## Design Changes for Non Material Ammendments to Planning Application to Planning Permission no. 6/2019/2014/ Outline

<b>Client</b>	One YMCA
<b>Project</b>	Pear Tree Lane Hostel
<b>Job number</b>	20211047
<b>Local Authority</b>	Welwyn Hatfield Borough Council
<b>Issued by</b>	Kevin Goldsmith
<b>Date</b>	07/12/22

*Filename: 20221207-047-WPA-F01-Design Changes Supplement for Non Material Ammendments\_Rev02.docx*

1 PROPOSED SITE PLAN
1 : 50

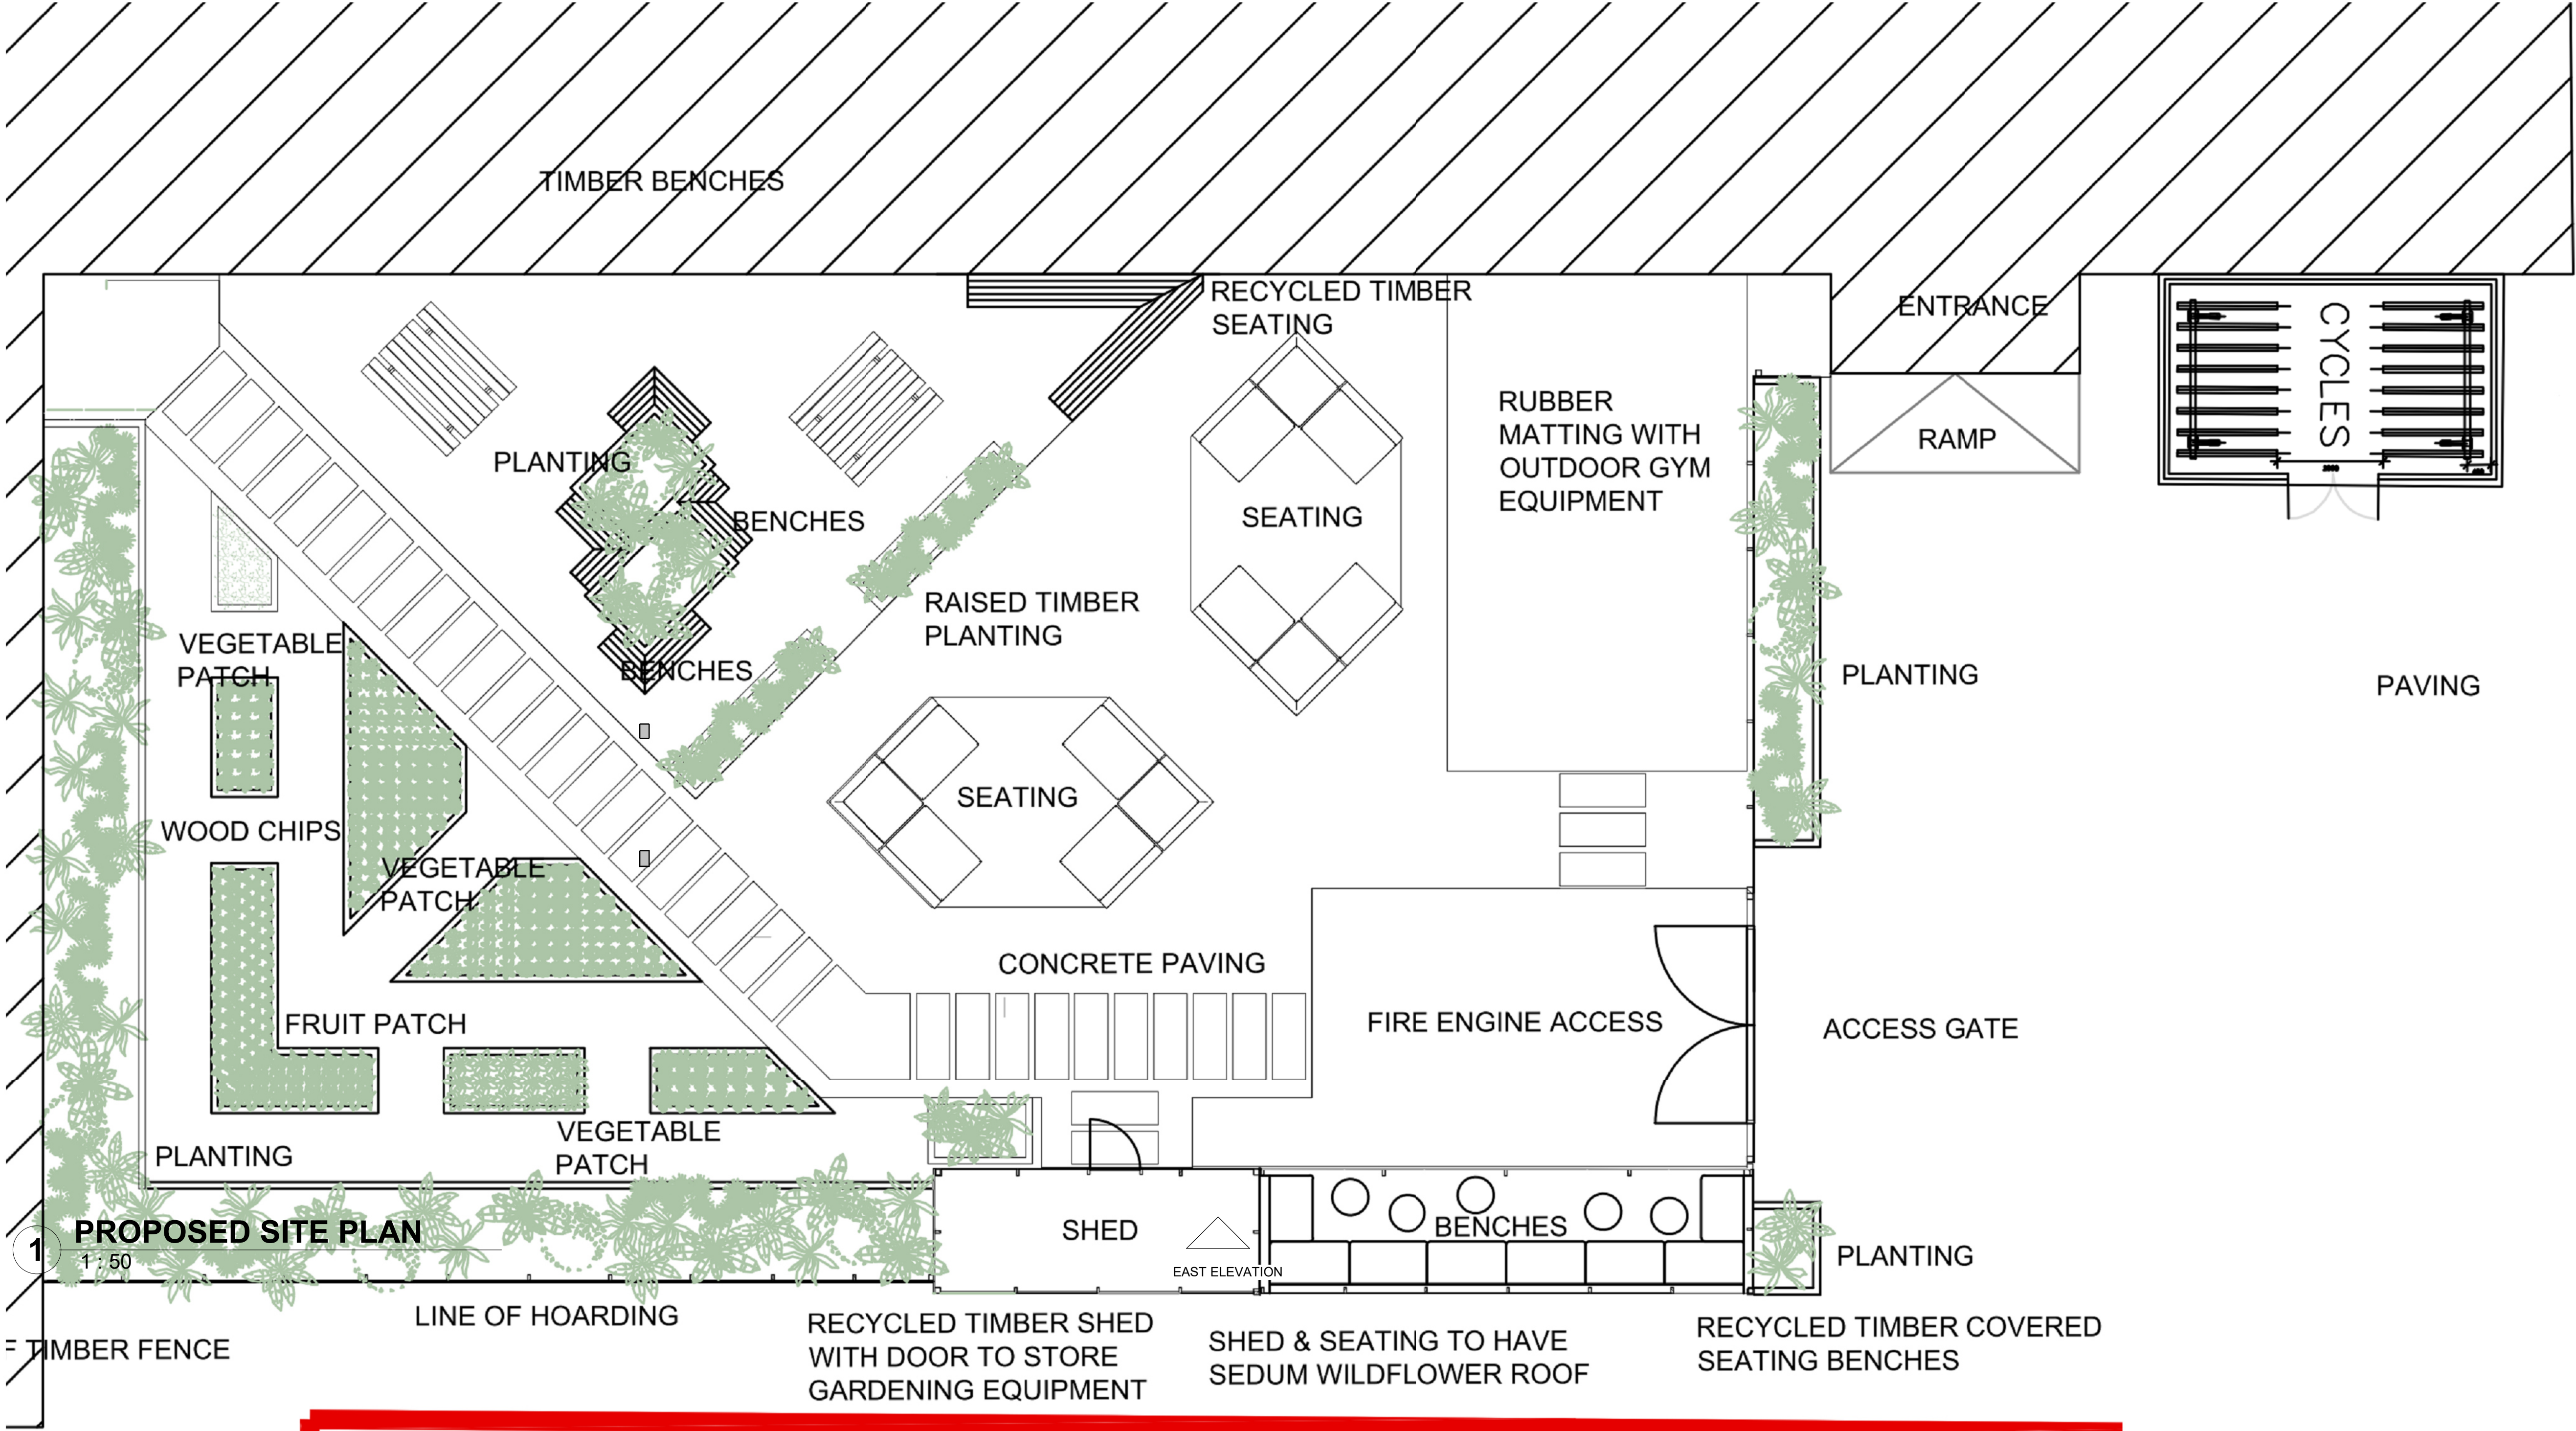
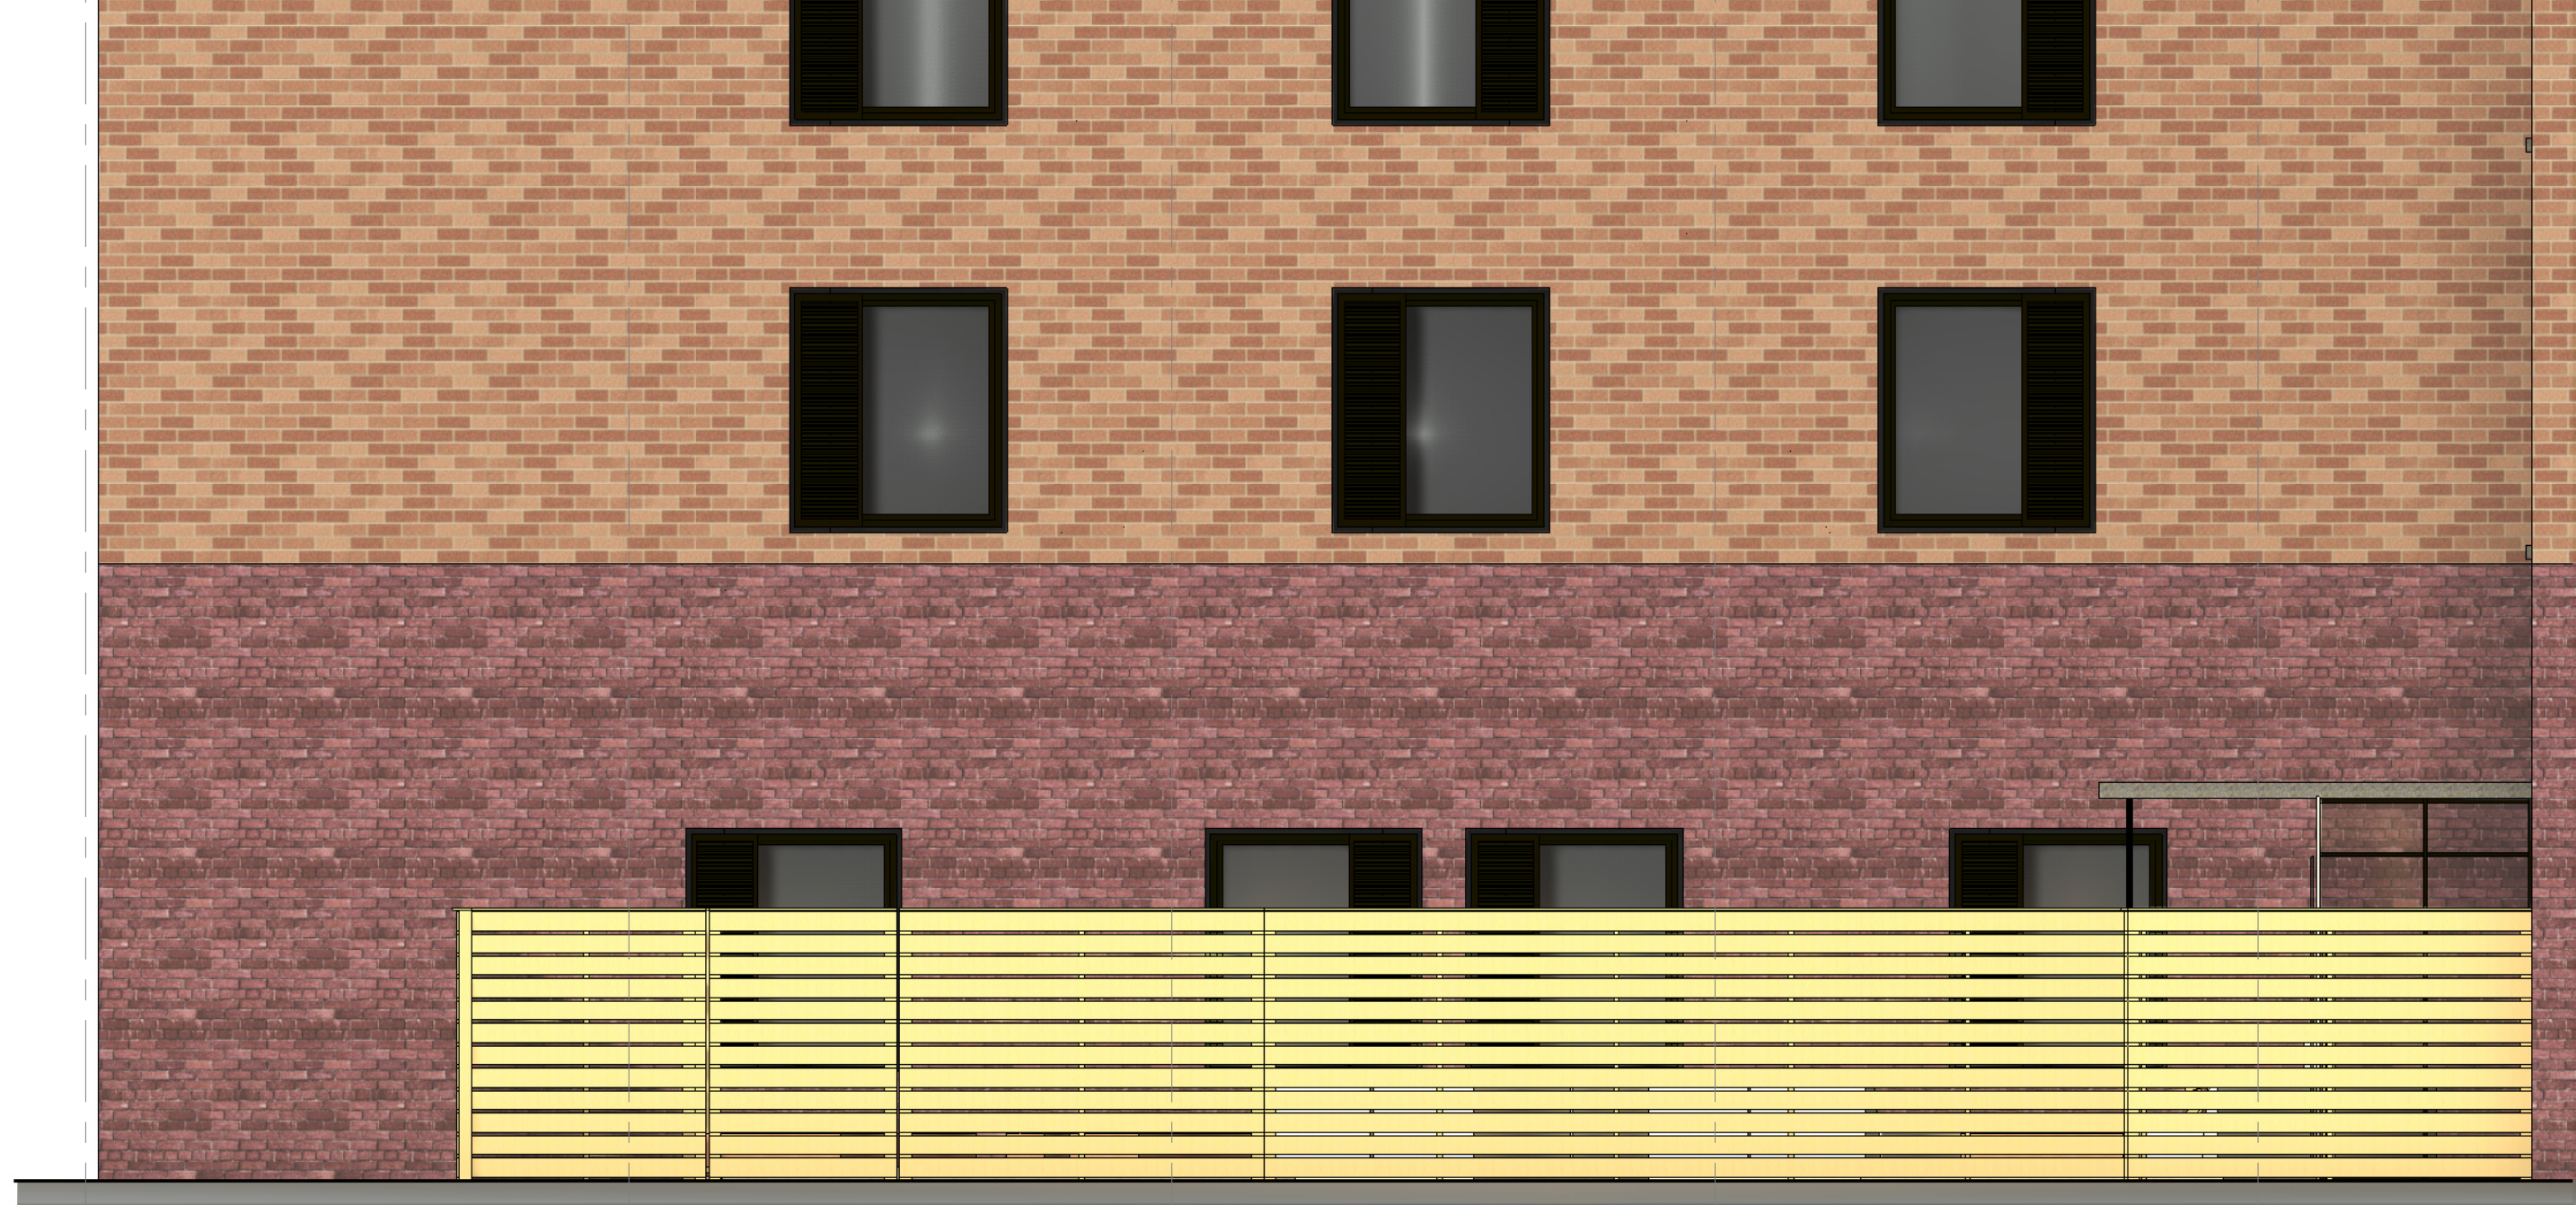
Item	Description of change	
<b>1.00</b>	<b>Site Plan - Externals</b>	
1.1	The original site showed no UKPN substation on the site, The site both hostel and residential development will require a new substation to be provided to accommodate the required loads for both developments and future use within the local area from the discussion with UKPN we have now located a new substation with OYMCA electrical switch room to the rear of the parking bays to the site out of view and also that access is maintained to parking spaces should UKPN need to undertake works to this. We have proposed a GRP enclosure for the substation and this forms a separate planning application.

1.2	The Bin Store originally had a secured area outside this has been omitted from the scheme and the location of the room has been relocated to the side of the building, moving it away from the main façade and providing more internal meeting room spaces for OYMCA to use.

1.3	<del>The cycle store was originally shown on the corner of the building next to the bin store enclosure this has been relocated away from the façade and adjacent to the communal garden space</del> This has now been relocated back to the corner of the building to provide better external space to the residents of OYMCA.

1.4	The communal garden space was originally confined due to the route through to the reception as this was located towards the corner of the building, The main entrance has been relocated along the façade closer to the car park with a shorter route. Providing a better view for staff for people approaching the building, this has allowed the communal garden space to fill this area and reduce the need for a public route along the front of the Hostel.

1.5	Minor Landscaping changes to allow better access to site and incorporating planting areas.	
<b>2.00</b>	<b>Building size + GIA</b>	
2.1	There is a slight increase in the building footprint, this is due to providing better internal living spaces for the residents as well as investigating a modular option for construction, We have moved away from modular construction but maintain the new footprint, we have also simplified the façade line at ground level, this is mainly confined to the internal courtyard elevations. The dimensions for this is around 500mm. The building length has not increased.  Please refer to the Comparison overlay which shows the original plan footprint in red overlaid the current floor plan.
